August 29, 2025

City of Albuquerque
Planning Department, Development Review Services
Attn: Anthony Montoya, Jr., P.E., CFM
Senior Engineer, Hydrology

**RE: Eisenhower Pool Site Imps.
Response to Review Comments dated August 28, 2025
Hydrology File: E21D007
Case # HYDR-2025-00310**

**CG-100**

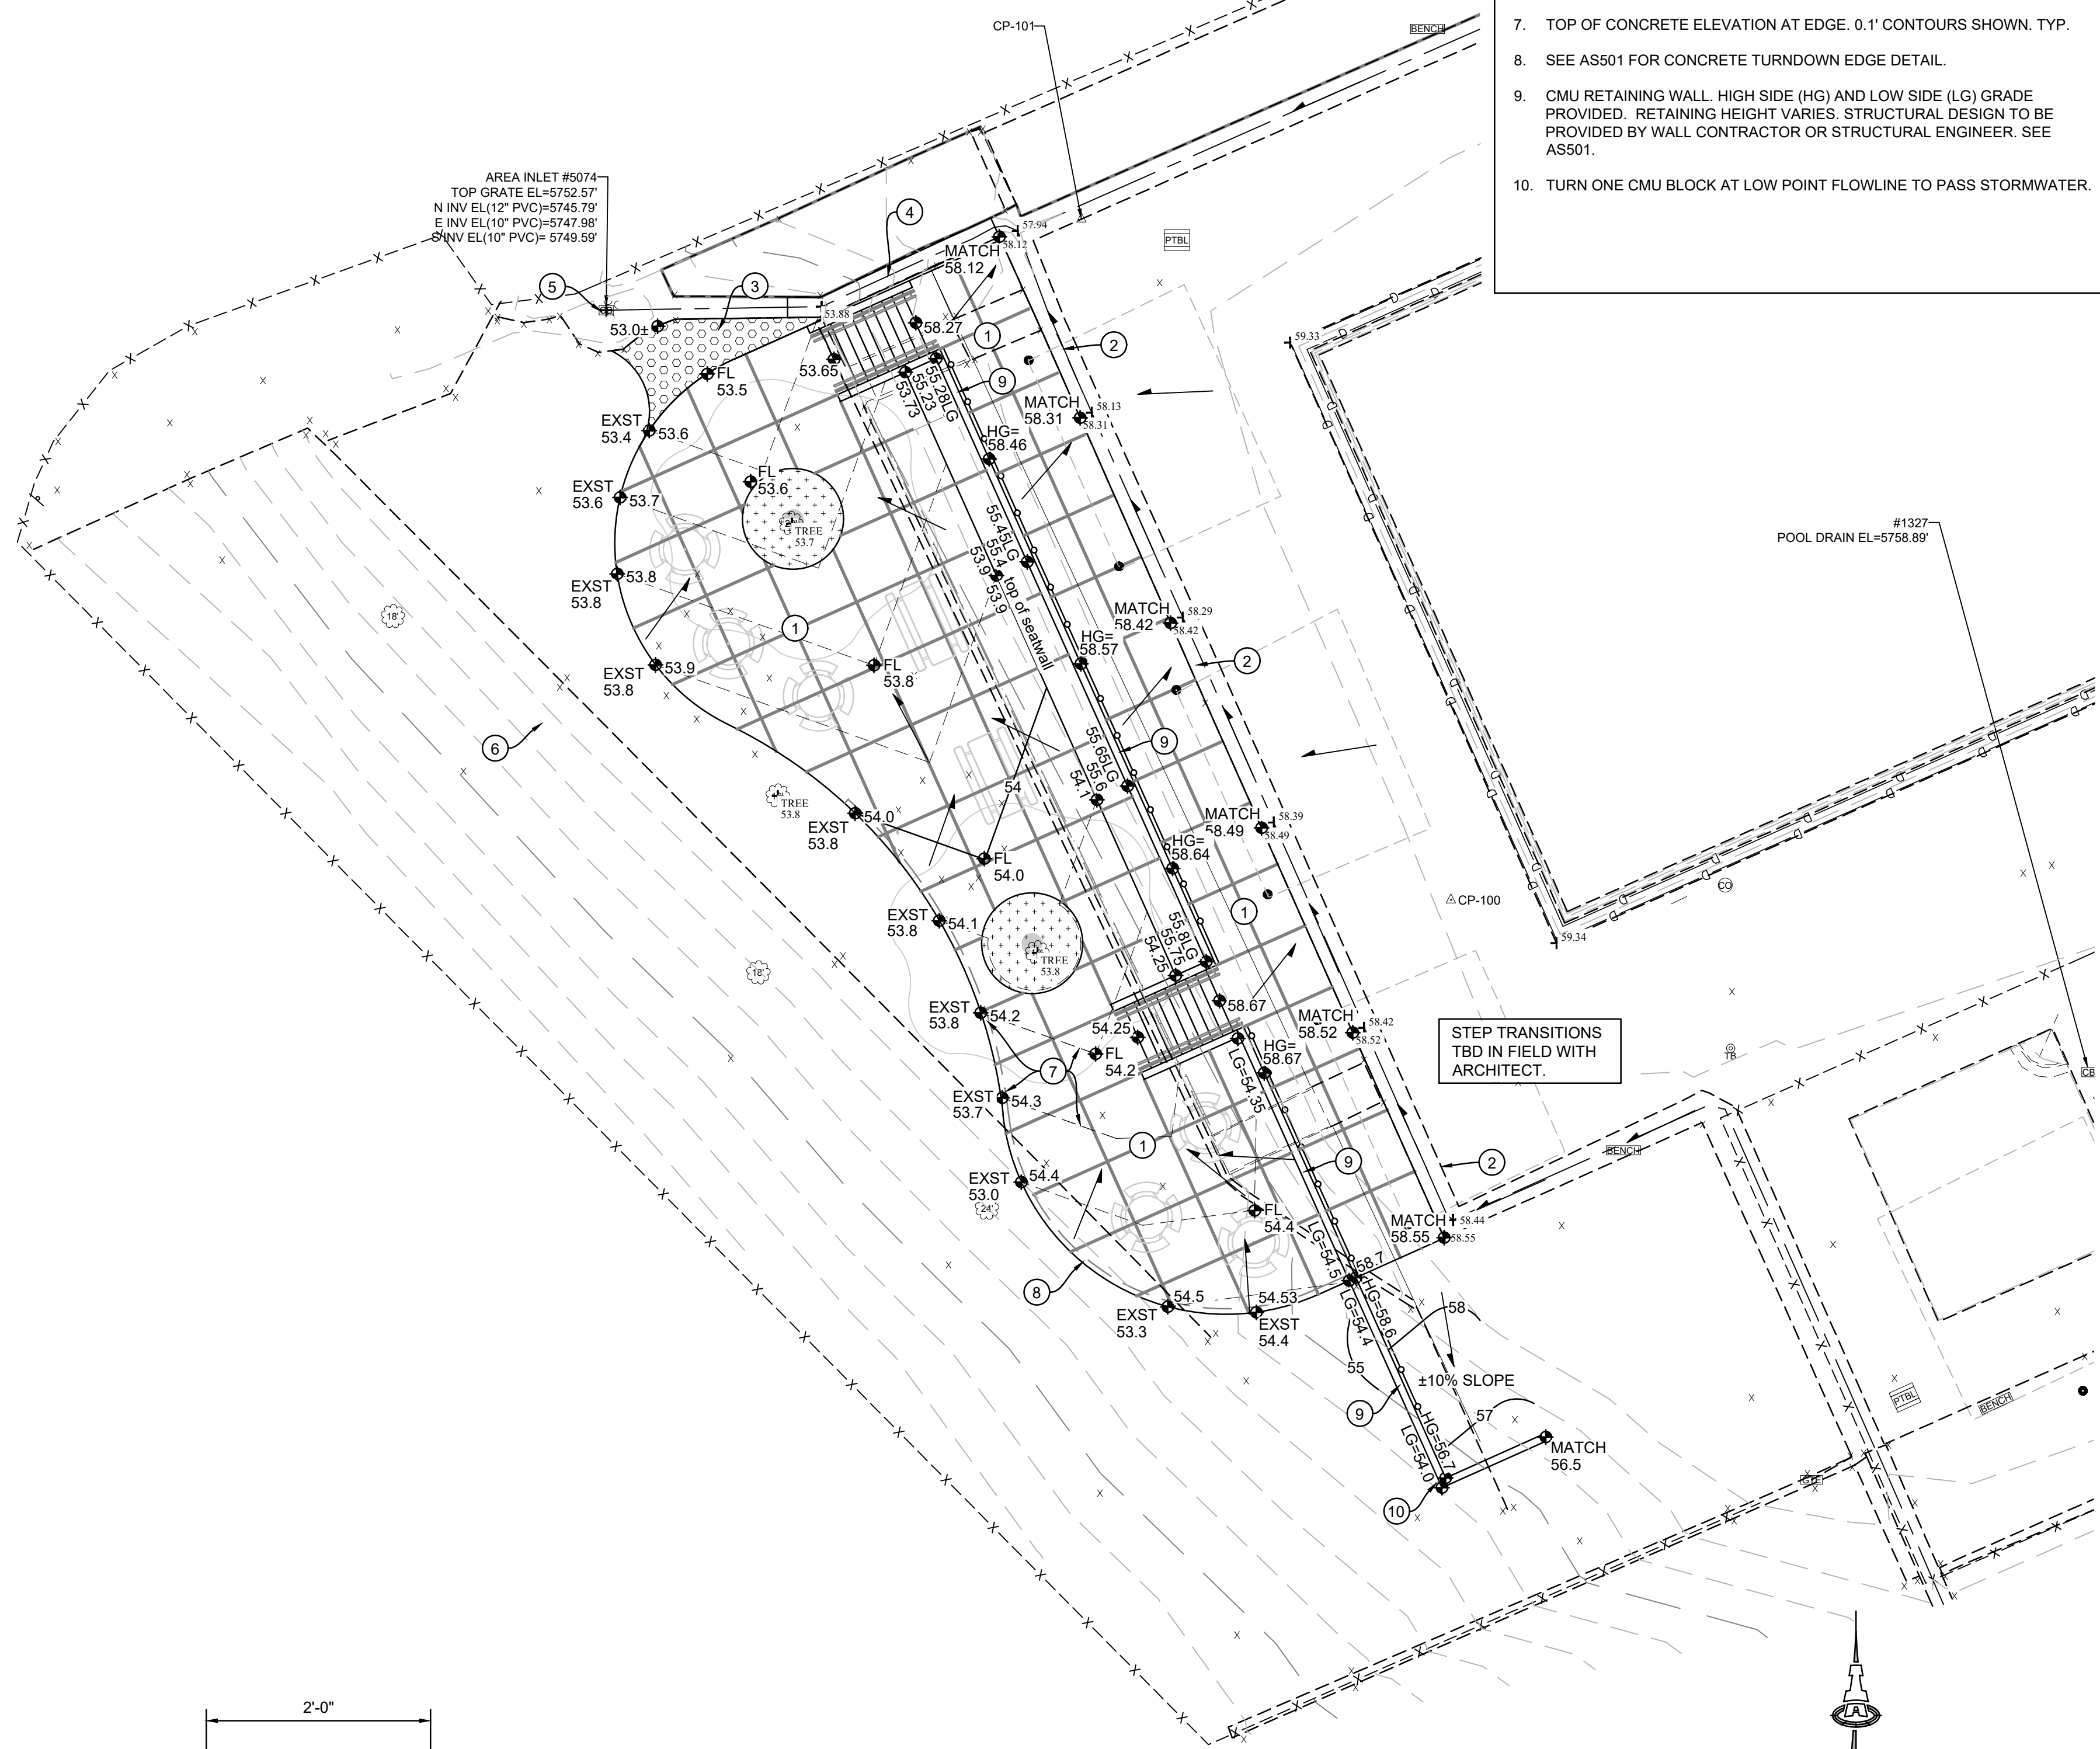
1. Survey provided Control Points @ NAVD 1988 are included in Project Information.
2. The FIRM Map has been updated.
3. Per CABQ Hydrology File E21-D007, a Drainage Masterplan for the property was approved in May of 2009 (EISENHOWER MIDDLE SCHOOL MASTER DRAINAGE PLAN: Prepared by Wilson & Co. – stamp date 4-27-09). The calculations for the 100-year, 24-hour storm determine the ‘peak runoff and the total volumetric storage required for the detention pond’. The pool property is within Basin 203 which is calculated at 90% impervious. Flows within this basin are directed via storm drain to the south detention pond. Based on Google Earth imagery, the current impervious area within Basin 203 is considerably less (60%-70%). Therefore, the minor addition of impervious area for this project is accommodated in the current pond design.

4. The observation of the condition of the existing detention pond is not within the scope of this project. The topographic survey data provided by CABQ does not include this pond to confirm volume. If analysis of this existing detention pond is required, this will significantly delay the project construction. Regarding pond sizing, Basin 203 is calculated to be 5% ‘B’, 5%

'C', and 90% 'D'. Currently, Basin 203 appears to be between 30% and 40% 'B' (lawn / landscape) which represents a significant reduction in required volume.

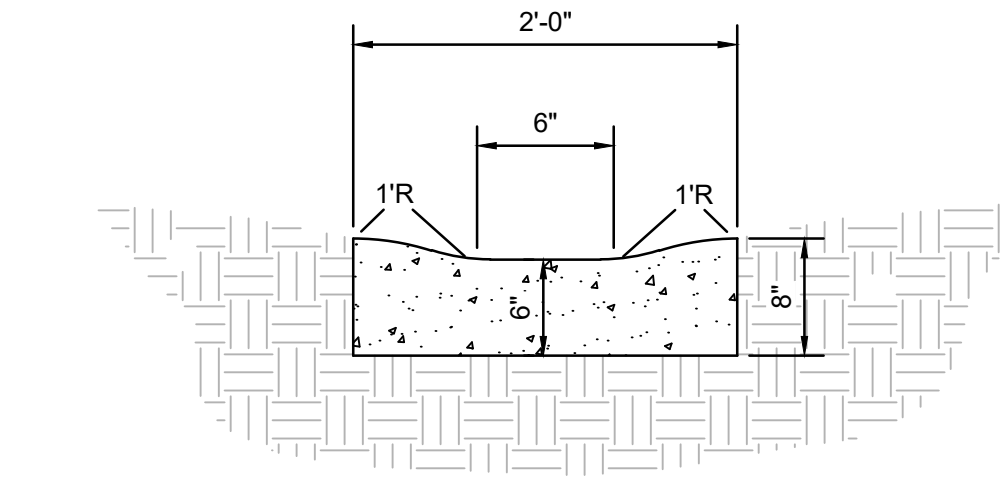
5. The Vicinity Map and FIRM Map have been updated to include a blue asterisk marker at the south end of the site. The image below identifies the area.
